From: Elaine Walby on behalf of Planning.Responses
Sent: 07 May 2026 16:00
To: Planning Scanning
Subject: FW: Public comment on application A/44/26/PL
Attachments: Neutral review of Application 7.pdf

Technical and Procedural Review of Application A/44/26/PL

1. Executive Summary

KEY TO HEALTH AND SAFETY SYMBOLS

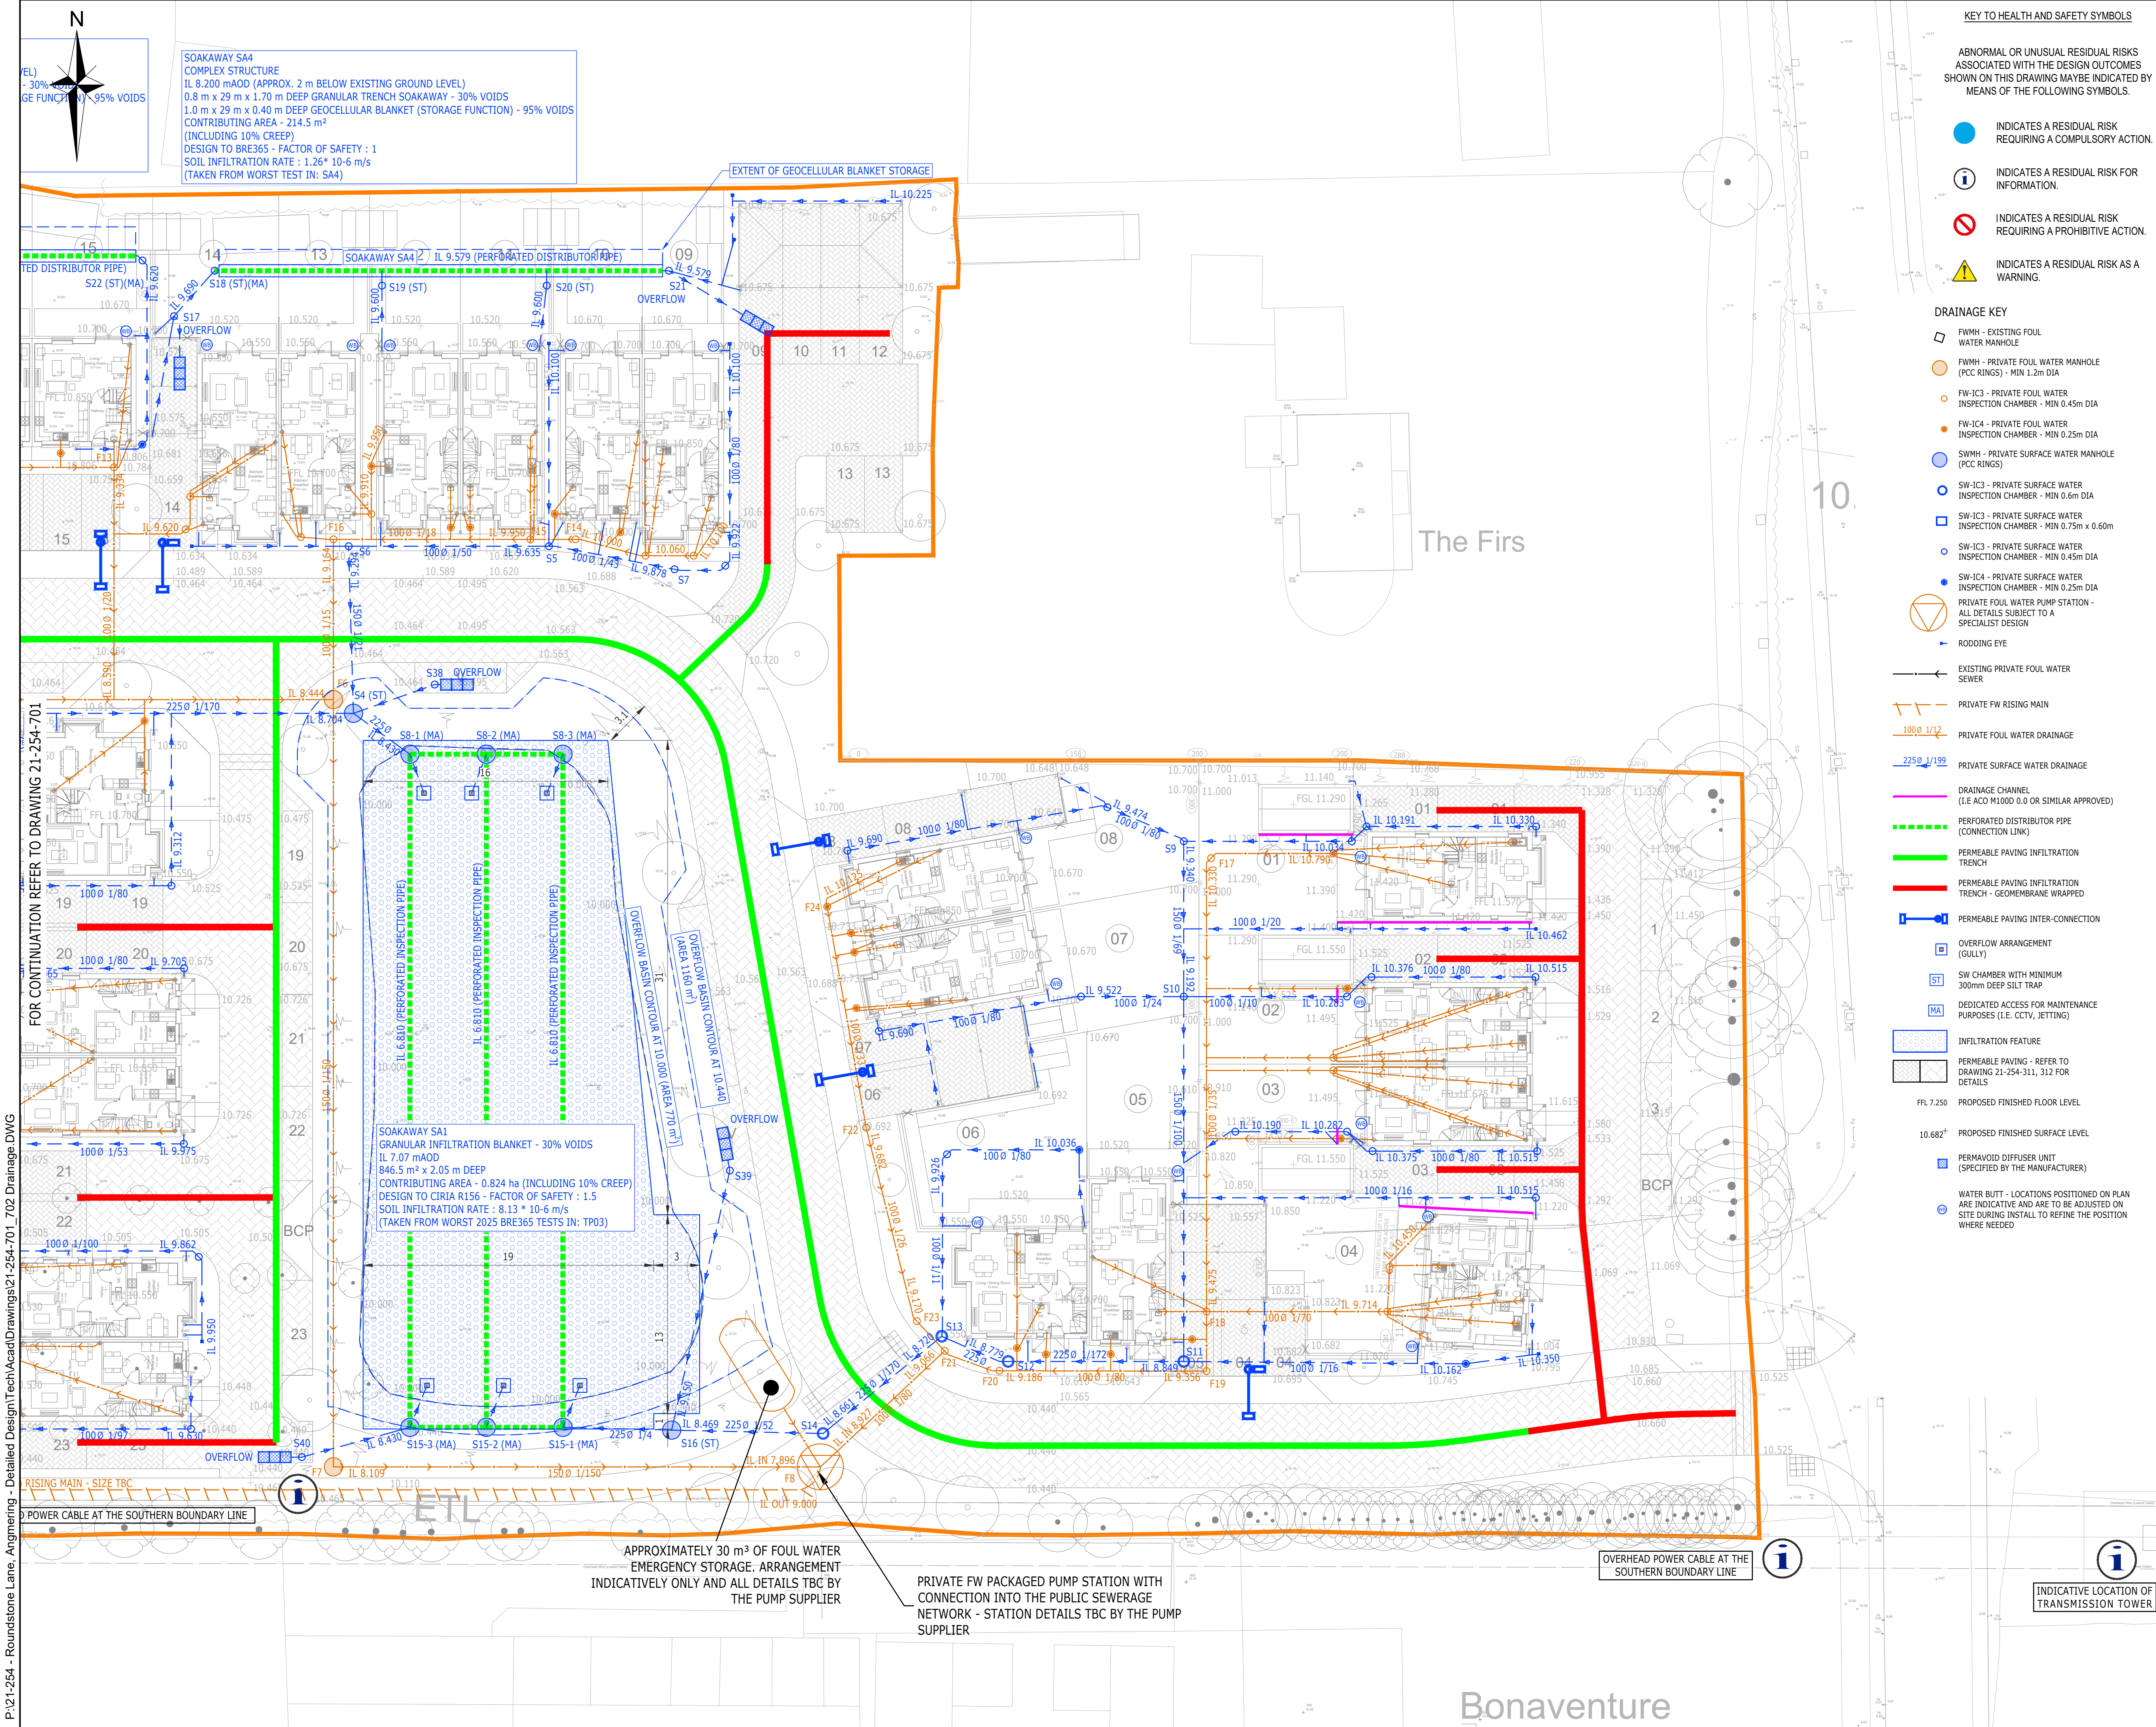
Features shown as present on the drainage drawings, including a rodding eye and inspection chamber with stated invert levels beside Plot 4, were not constructed on site. In addition, not all drainage construction drawings previously before the LPA appear to have been submitted with the present application.

Whilst it is noted in 2.7 that the surface water drainage management plan has been omitted from this submission, one assumes that any such plan would include the use of rodding eyes and inspection chambers such as these. This then raises the question as to how the plan can be coherent and executable if essential elements of the drainage system have not been constructed. The omission of these two particular features had already been brought to ADC's attention on 13 February 2026, almost a month before the date of this latest application.
